From:
Sent: 15 September 2023 12:38
To: DCAdmin
Subject: 2023/92255 - 2023/92327 - 2023/92254 - 2023/92253

2023/92255 Land at Green Acres Close, Emley, Variation of Conditions 1 (Plans) , 2 (Crime Prevention) and 15 (Permitted Development) of Previous reserved matters approval 2021/93286 pursuant to outline permission 2020/91215

And
2023/92327 Land at Green Acres Close – modified plans for 6 Dwellings plus parking and landscaping and modified plans for ball stop netting.

Comments and objections;

Project		Residential Development of Wentworth Drive, Emley	
Client		Barratt Homes	
Drawing		Section 104 Layout	
Drawn By:	TM	Date:	05/01/2022
Checked:	GS	Scale:	1:250
Drawing No:	AMA/21311/D/500	Rev:	P6

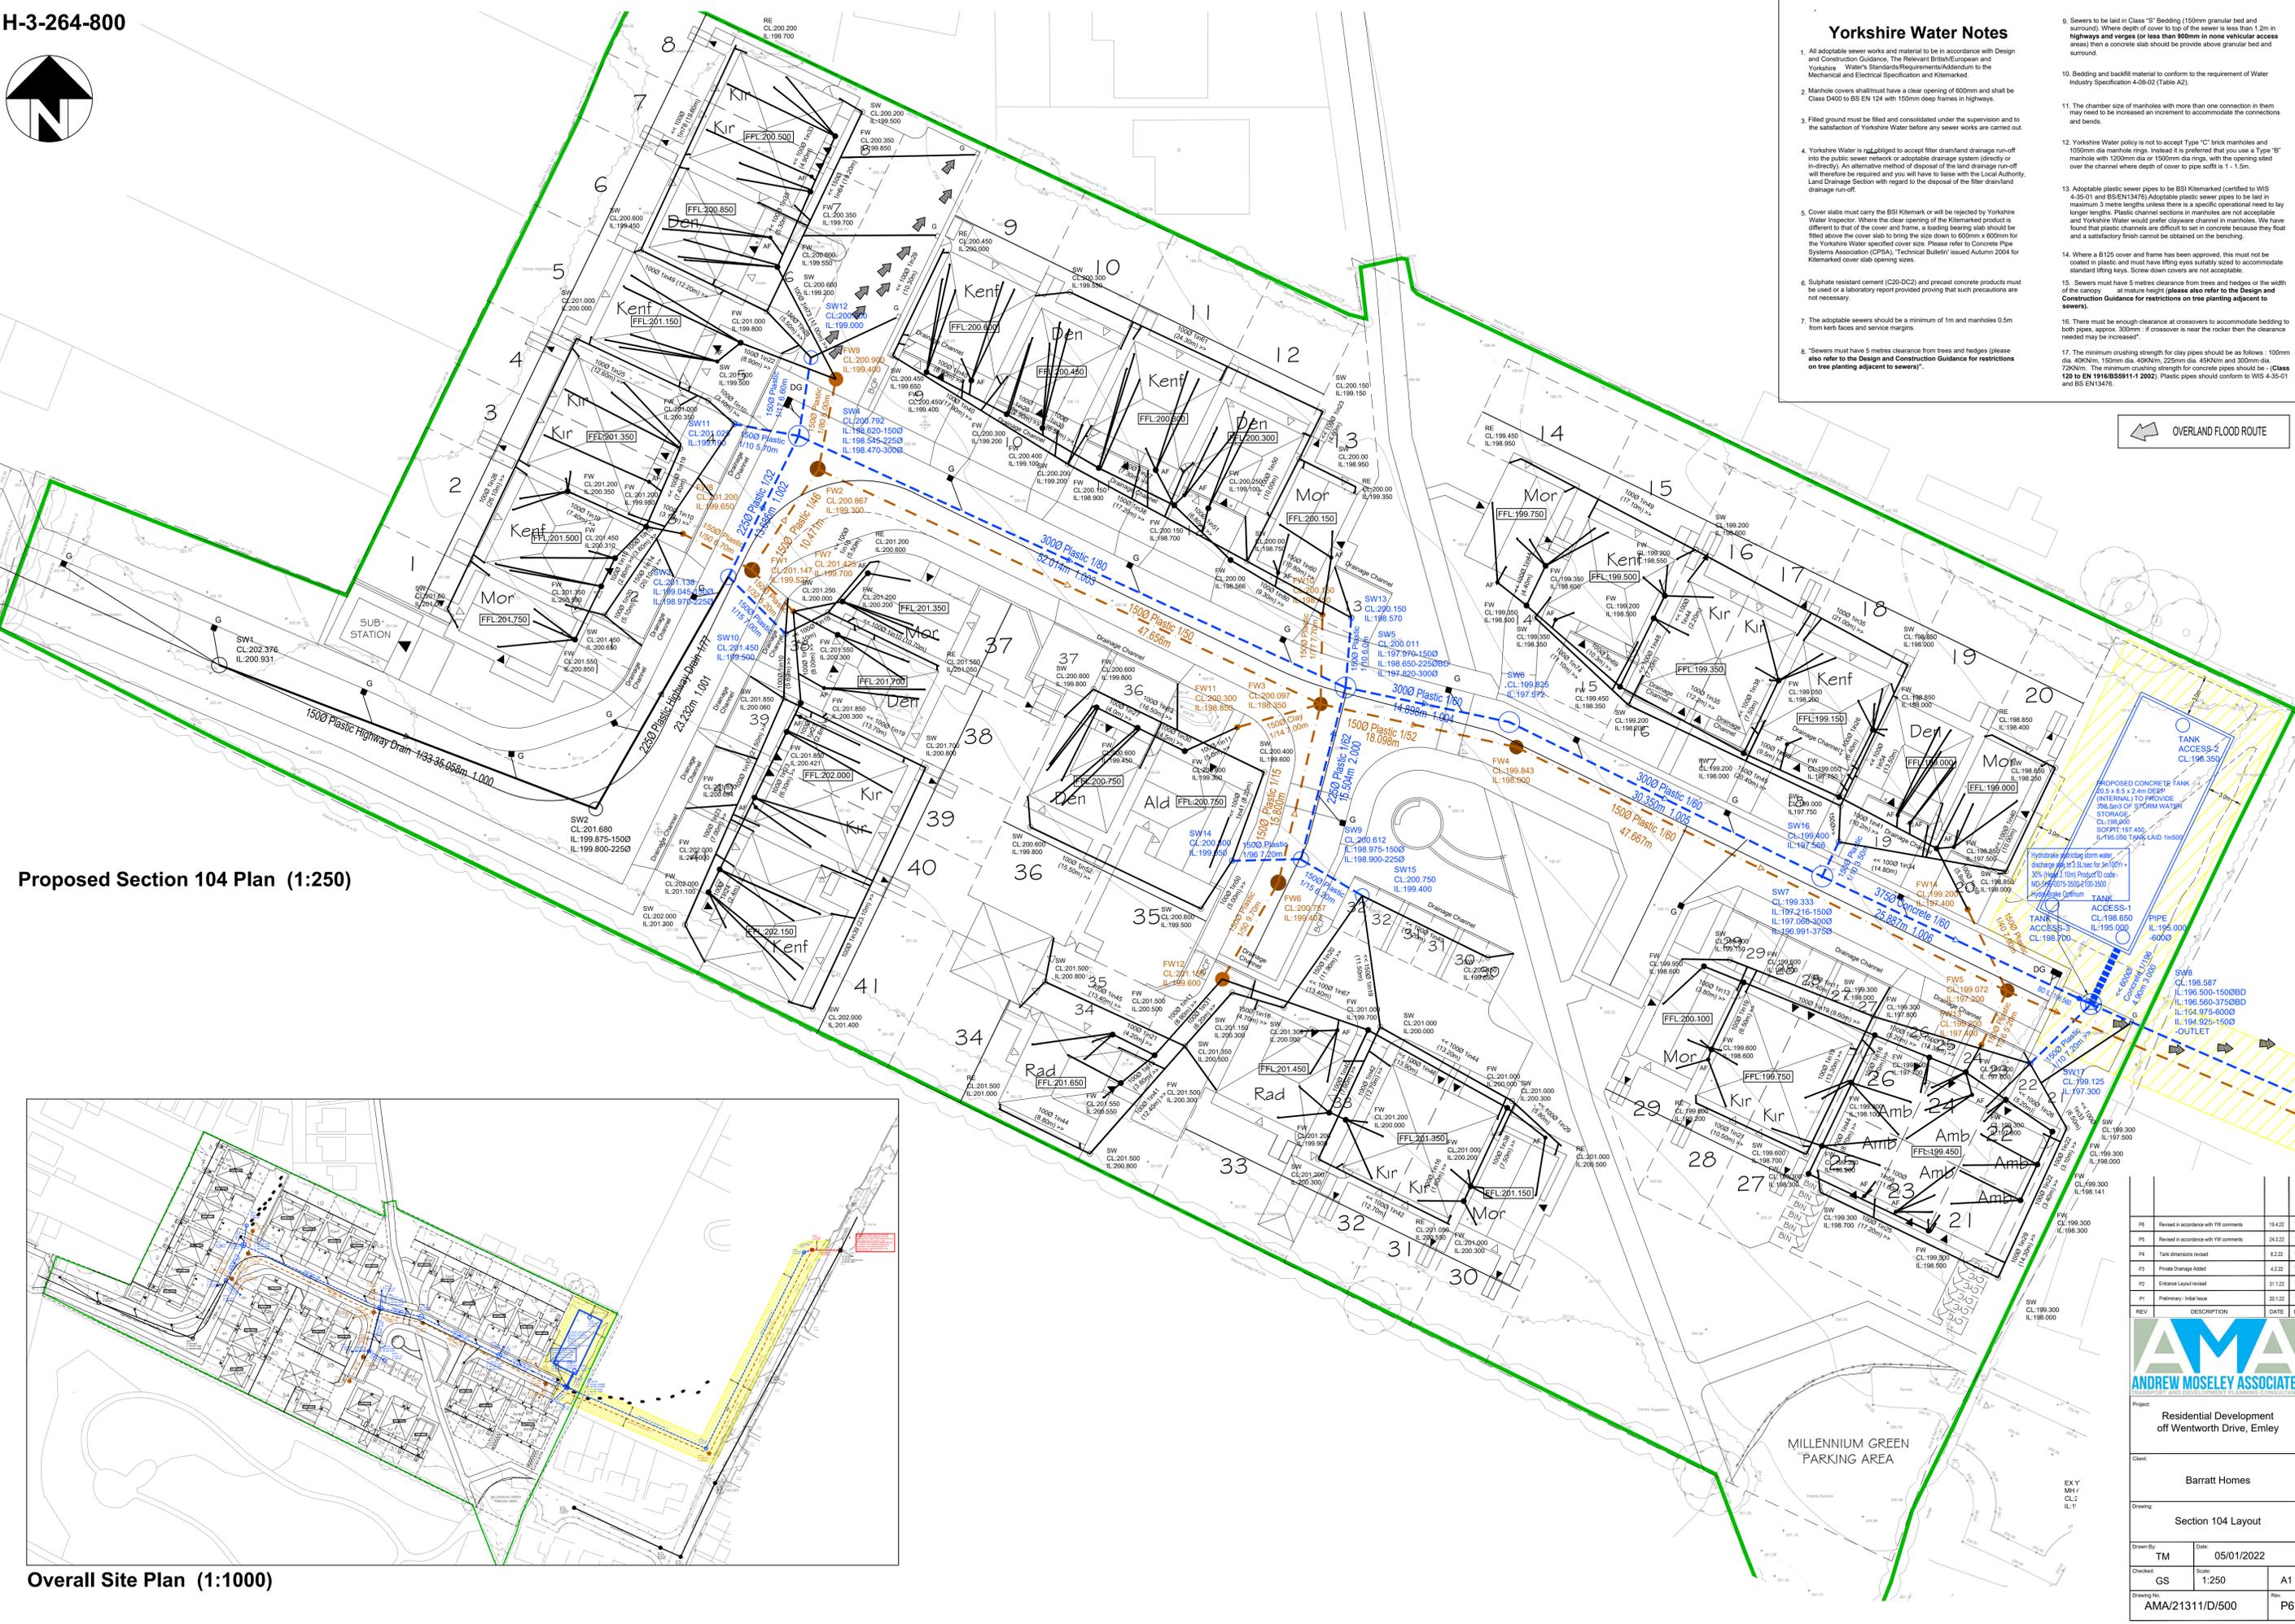
Newett Homes have submitted plans for temporary drainage that will affect the parking area and entrance to the Emley Millennium Green – Any drainage plans that affect the parking area or entrance must be discussed and agreed with the Trustees of the Green and must not block or impede the area at any time.

- Appendix A - Construction Management Plan (drawing reference NLM-005-A)
- Appendix B - Standard Mitigation Measures
- Appendix C - Additional Mitigation Measures
- Appendix D - Mud & Debris Controls

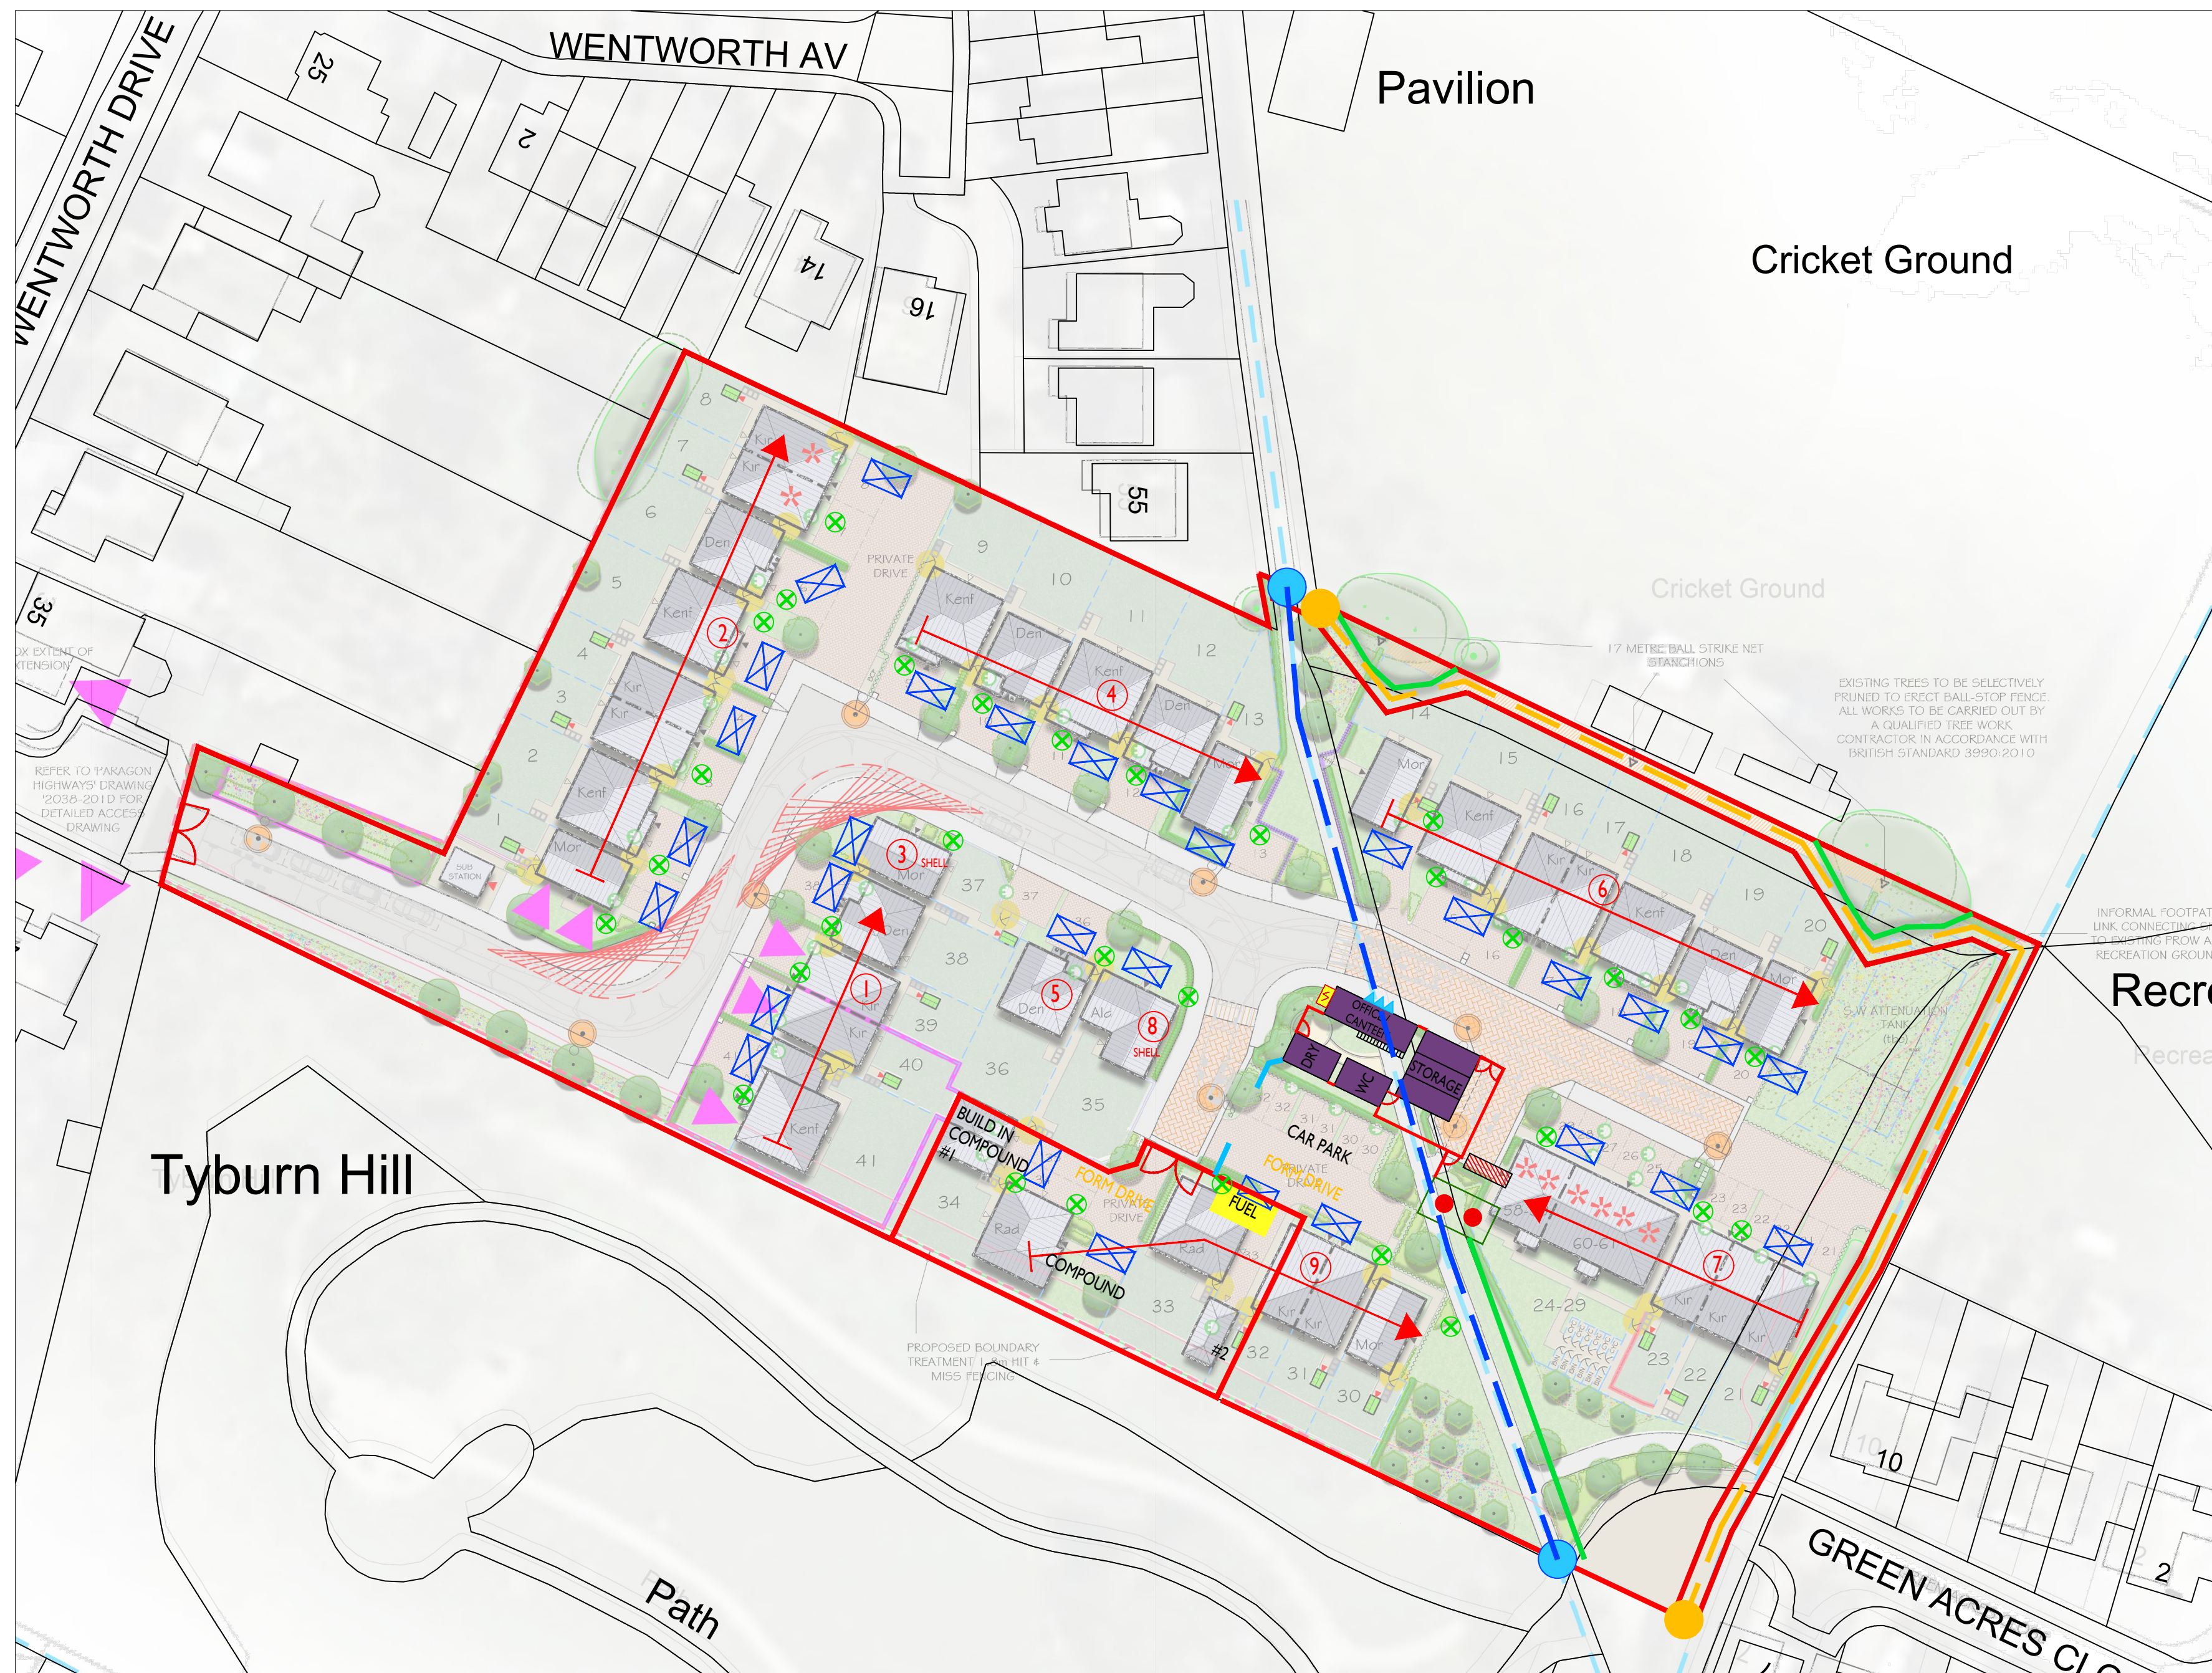
1 - How do Newett Homes propose to protect the Millennium Green's trees, bushes and wildlife during the development from construction debris, dust and mud, from excess construction noise and artificial lighting. The Millennium Green is used for the release of recovering hedgehogs from the nearby hedgehog hospital. Newett Homes is aware of this and has been approached by the hedgehog hospital with a request to enter the development site to monitor and/or re-

2 – How will Newett Homes ensure access to the Emley Millennium Green and other public areas are not impeded during the development.

3 - There has not yet been any clear communication from Newett Homes on what will happen to the existing public right of way (PROW DEN/21/20) that crosses diagonally across the site and is the main route to the Millennium Green which has been recently fenced in by contractors. We assume this right of way will remain open during the course of the development as was the intention during the planning process? Are there plans to divert this PROW? The recently submitted 'Secure by Design' layout dated 11/07/2023 appears to refer to a diversion? If so where exactly will the diversion be and how long will the PROW be diverted for? We assume if there is to be a diversion it will be only for a short space of time at critical points during the development and not for the duration of the development?

6 – Parking of construction workers vehicles will be an issue, what are the plans?

7 – Reassurance that the access from Green Acres Close will not be used by construction workers or deliveries.
